10 Dowry Square, Hotwells

Addendum to Design and Access / Heritage
Statement setting out proposed changes to
22/01475/H and 22/01620/LA

**First Floor and
Extension Roof
Plans As
Proposed**

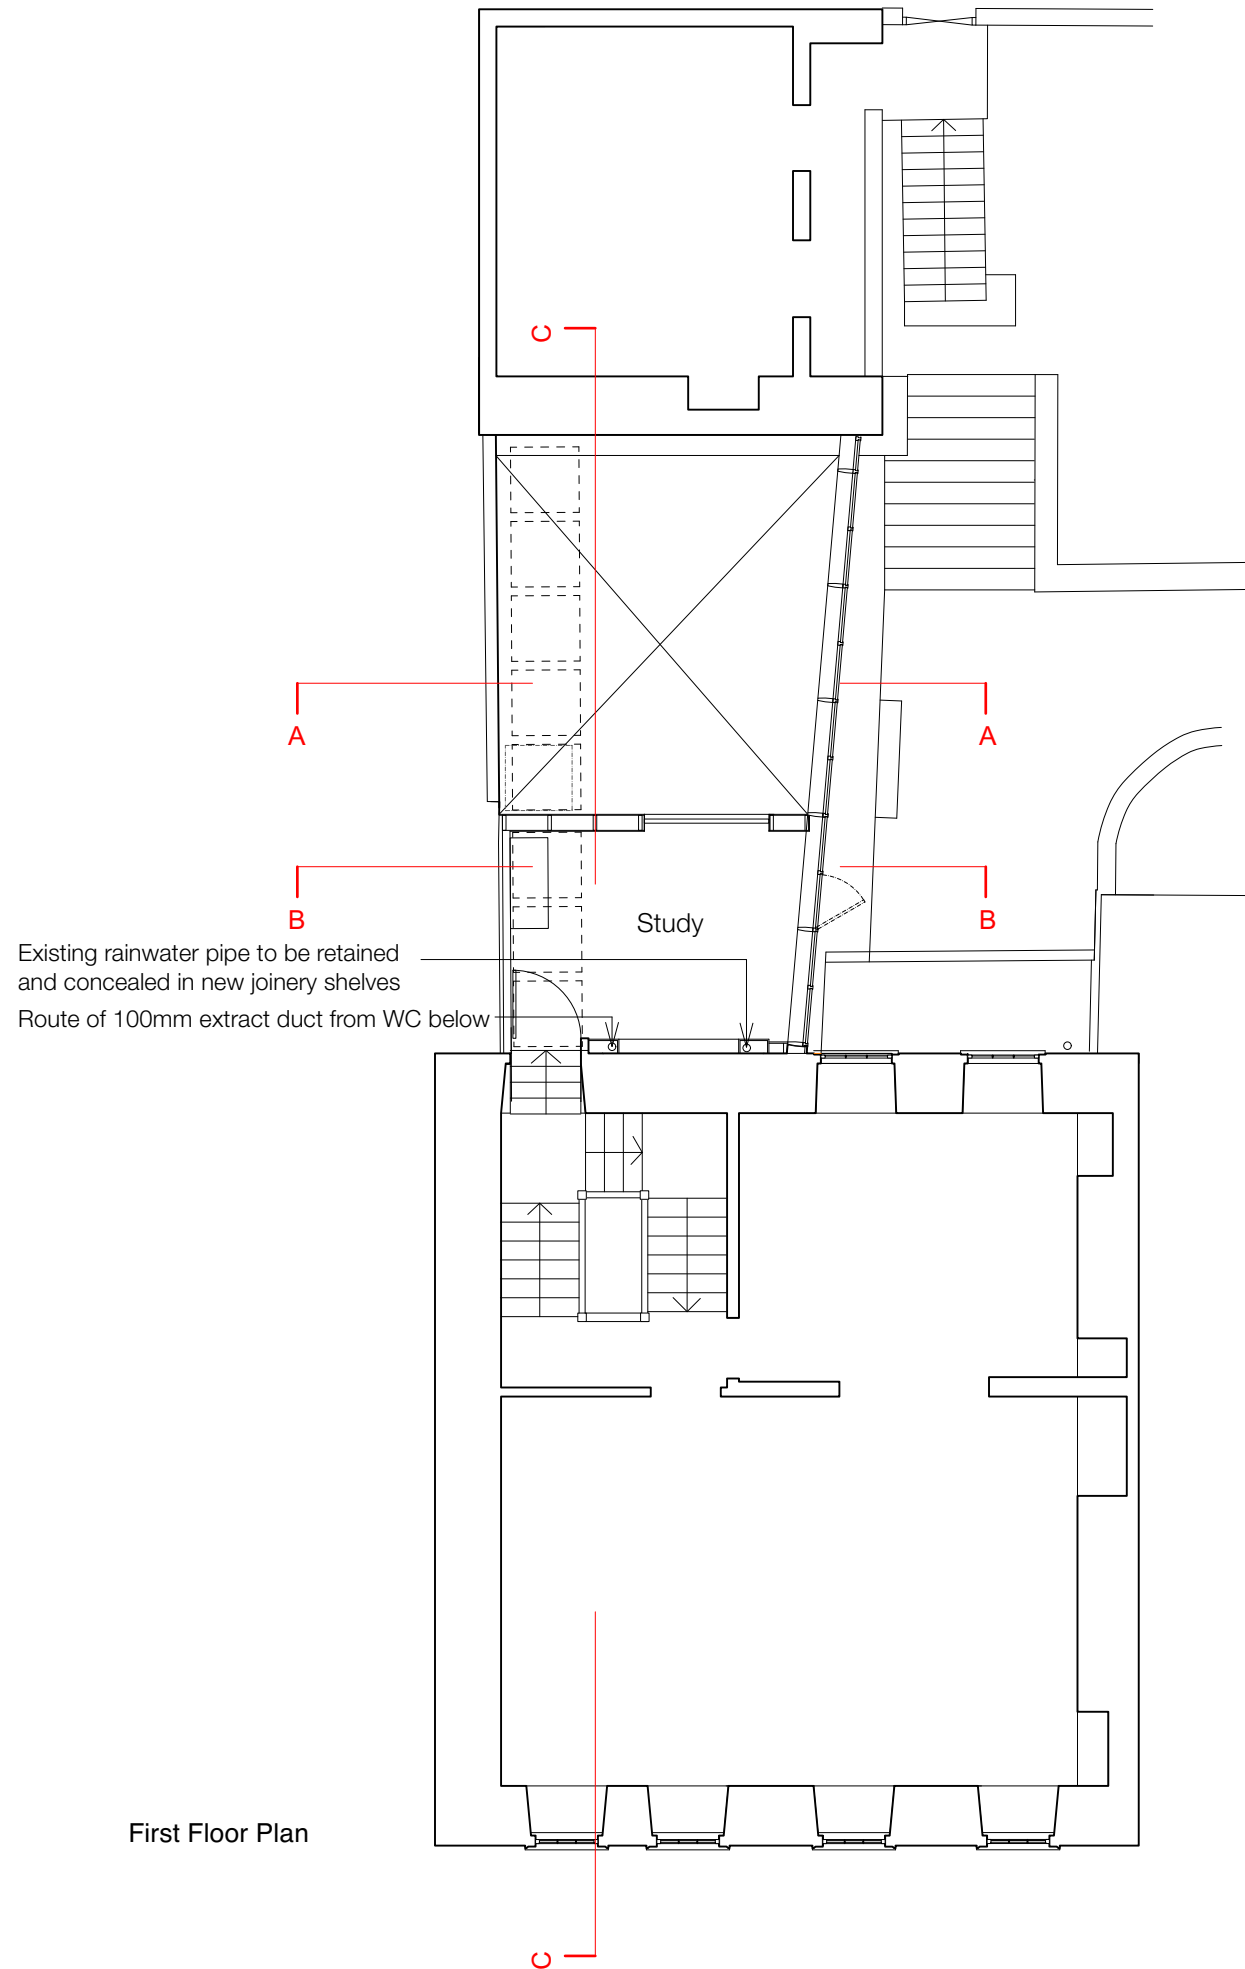
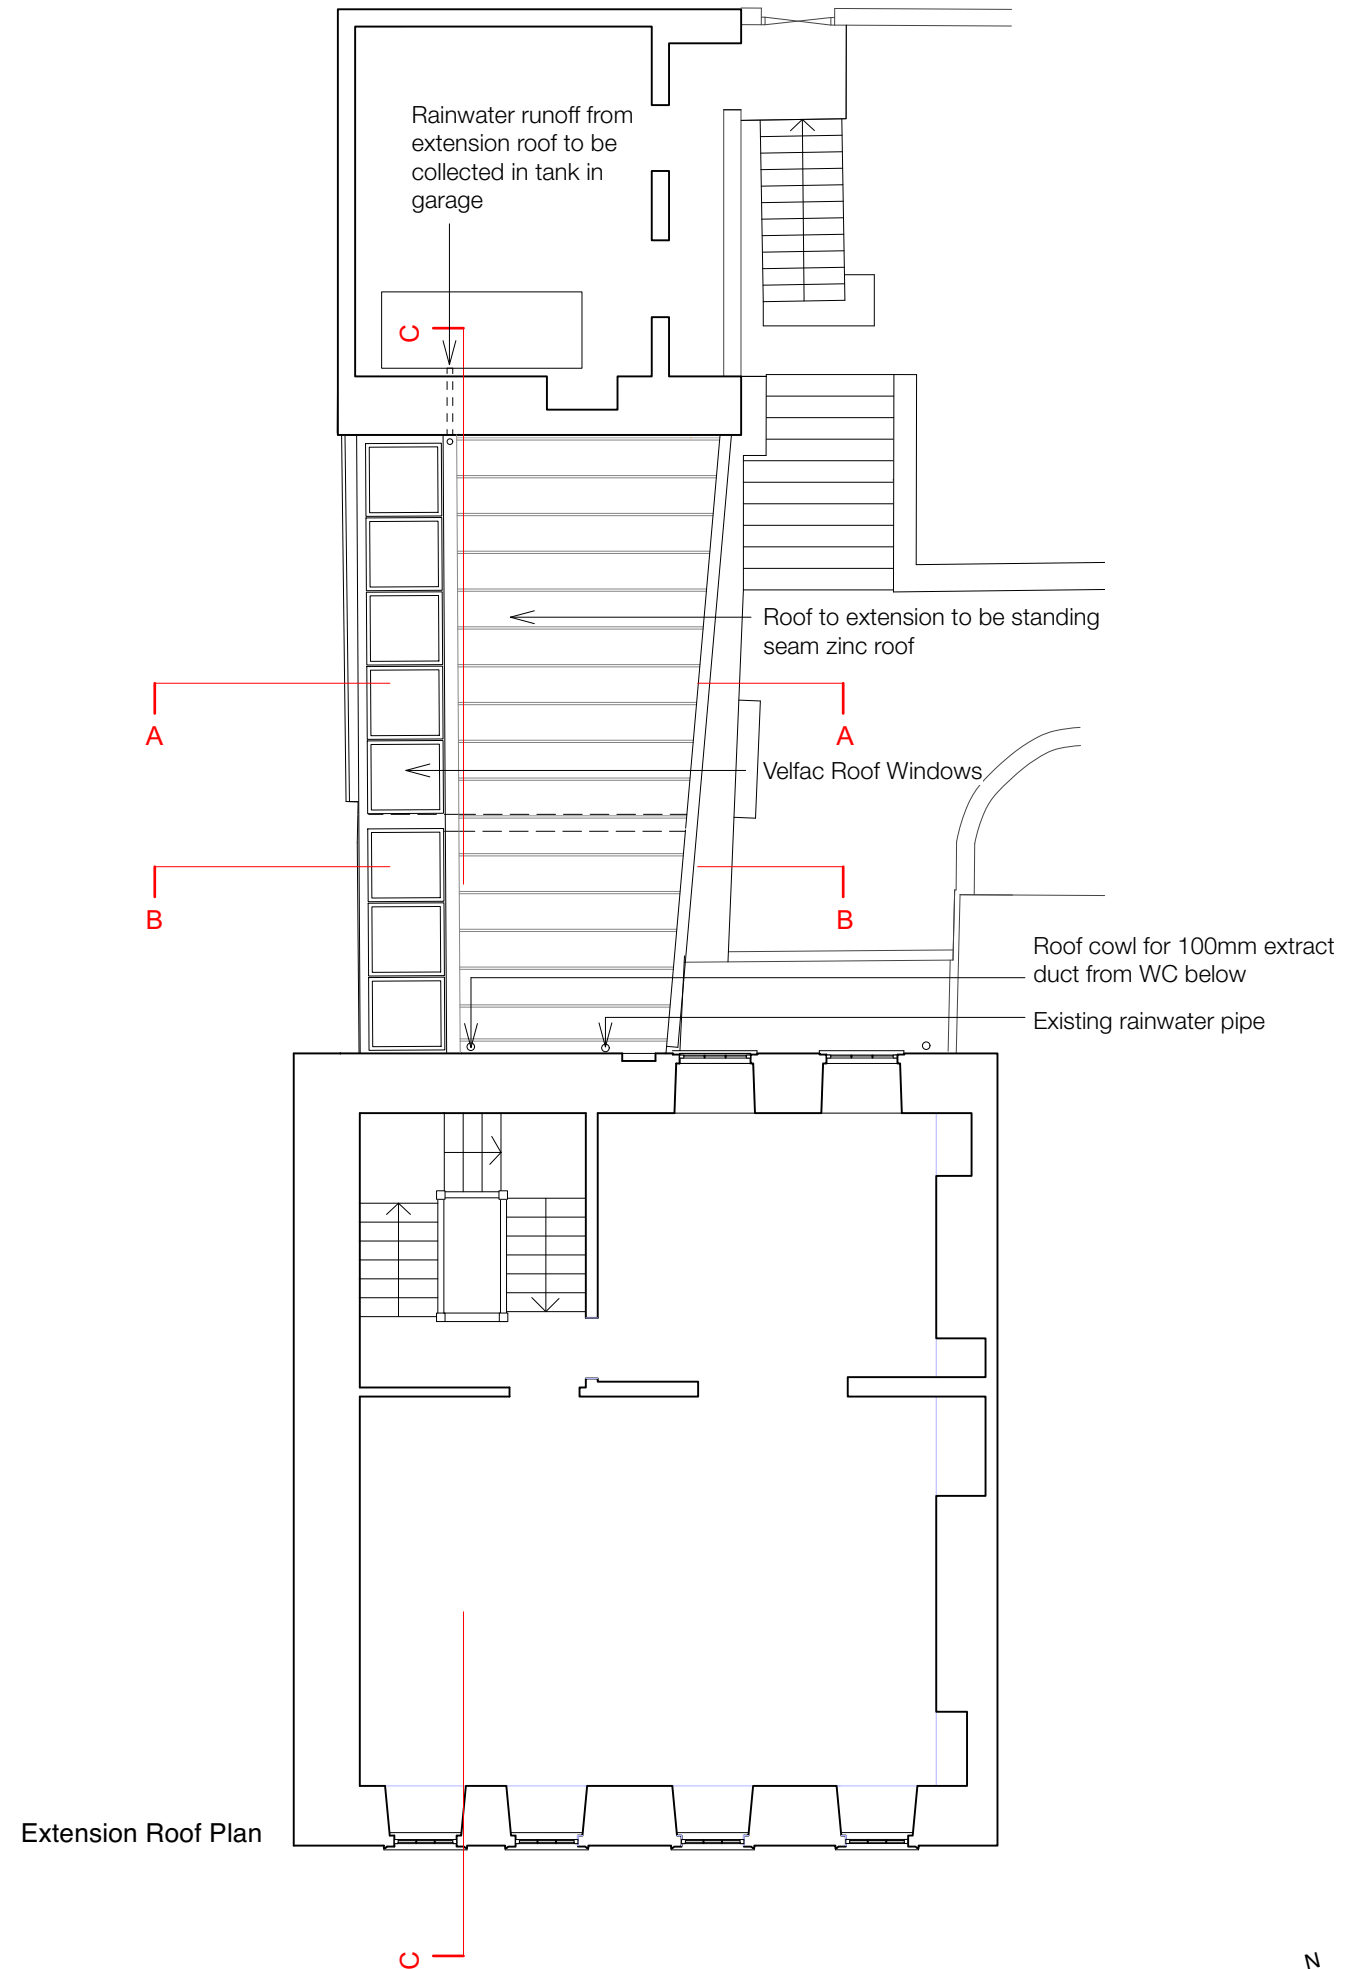
The first floor plans on this page of the consented scheme and the revised proposal show the omission of the new cavity wall on two sides of the double height orangery space.

In order to provide sufficient ventilation and avoid overheating in the conservatory space we have proposed a slightly different roof light system - the Velux Modulator roof light system that allows fixed and opening roof lights within the same frame profile.

The roof plans on this page show the consented scheme and the proposed revised scheme. This illustrates the new roof light arrangement and the new standing seam zinc roof.
